From: Laura Gibbons
Sent: 22 January 2019 11:56
To: Planning.Responses
Cc: Richard Castro-Parker
Subject: RE: Planning Consultation on: BE/139/18/PL

Engineers Comments Regarding Surface Water Drainage

APPLICATION **BE/139/18/PL**

Description of Works: Erection of an industrial building ancillary to existing operations.

Proposed Site Plan 1:1000

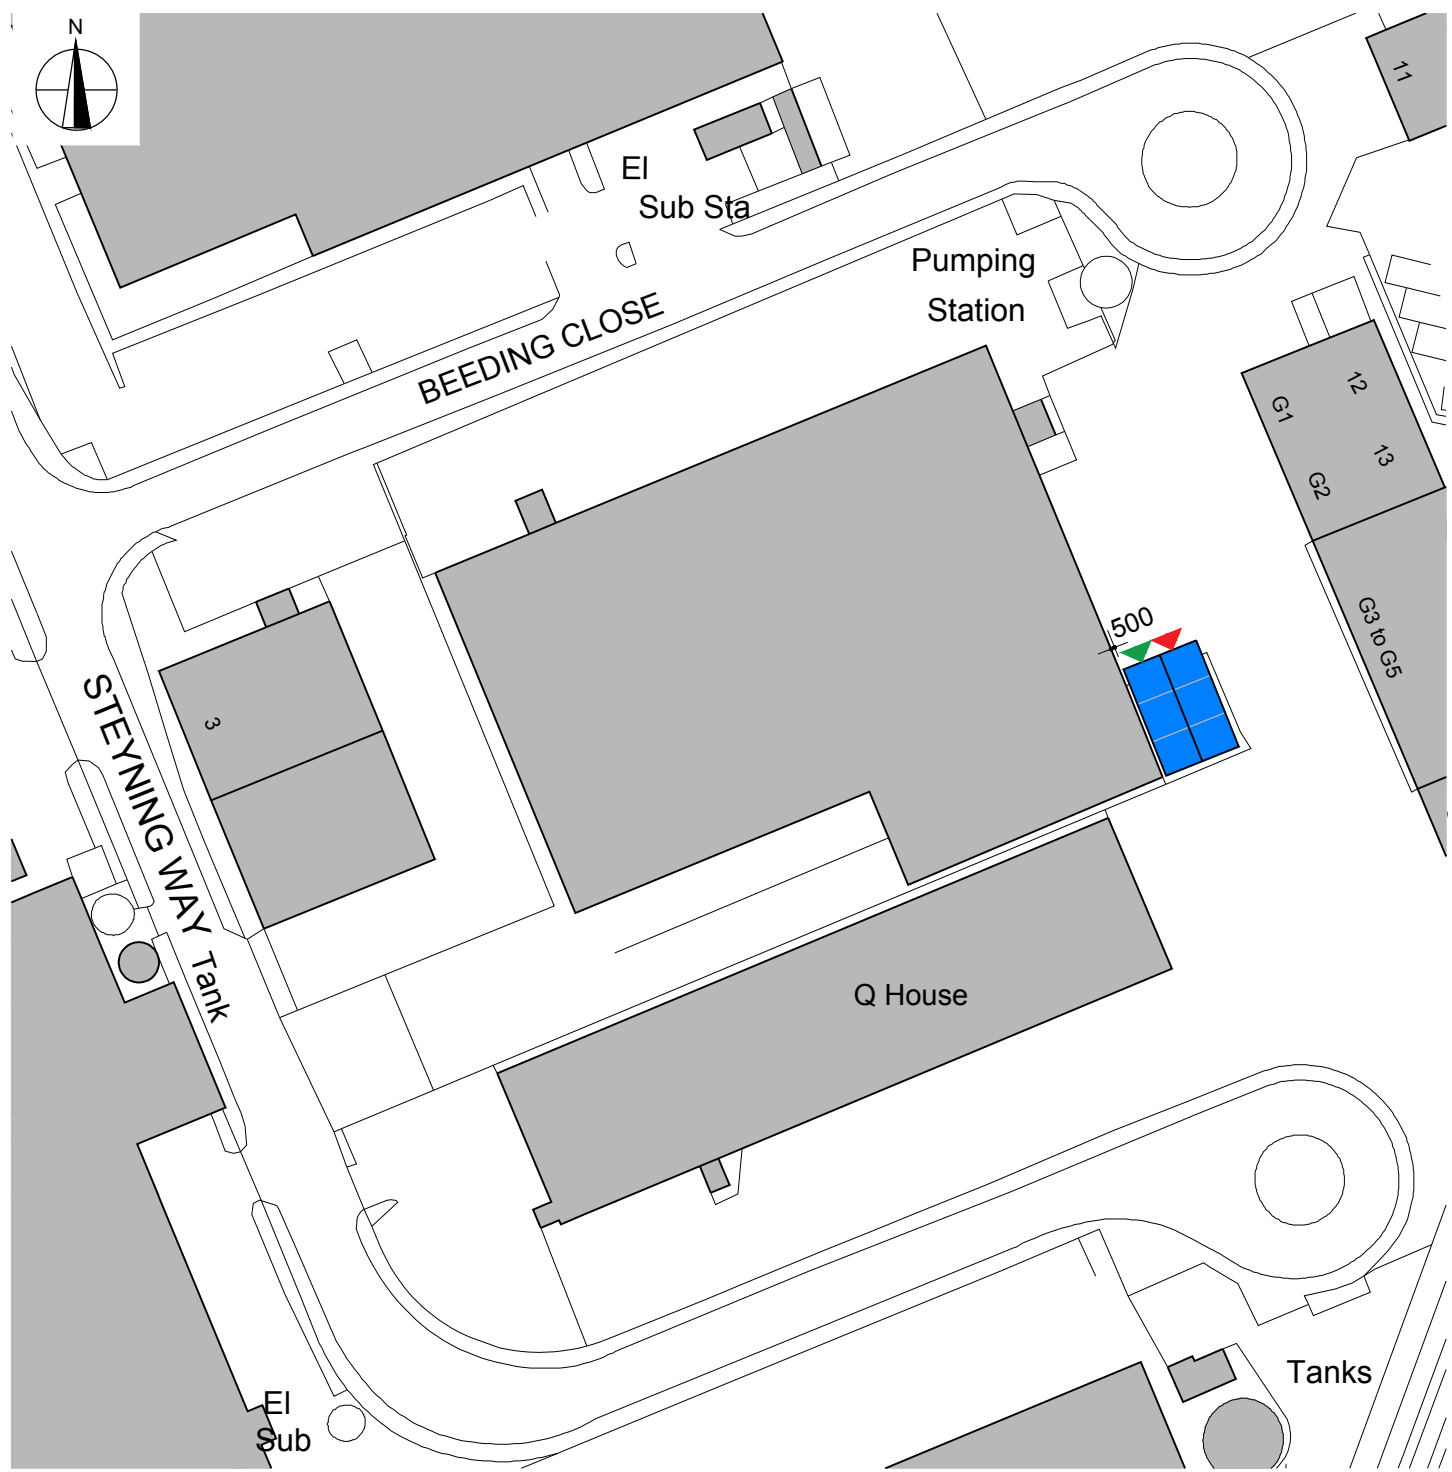
The proposals are to drain surface water on to new hardstanding and into existing linear drainage channels. The efficacy of the drainage channels to accept these flows has not been determined. Furthermore, these proposals do not follow the hierarchy for sustainable drainage. They are not acceptable.

Please apply **ENG2B**.

Infiltration must be investigated.

Infiltration rates for soakage structures are to be based on percolation tests undertaken in the winter period and at the location and depth of the proposed structures. The percolation tests must be carried out in accordance with BRE 365, CIRIA R156 or a similar approved method and cater for the 1 in 10 year storm between the invert of the entry pipe to the soakaway, and the base of the structure. It must also have provision to ensure that there is capacity in the system to contain below ground level the 1 in 100 year event plus 40% on stored volumes, as an allowance for climate change. Adequate freeboard must be provided between the base of the soakaway structure and the highest recorded annual groundwater level identified in that location.

Any SuDS or soakaway design must include adequate groundwater monitoring data to determine the highest winter groundwater table in support of the design. The applicant is advised to discuss the extent of groundwater monitoring with the Council's Engineers. Supplementary guidance notes are also enclosed for information.
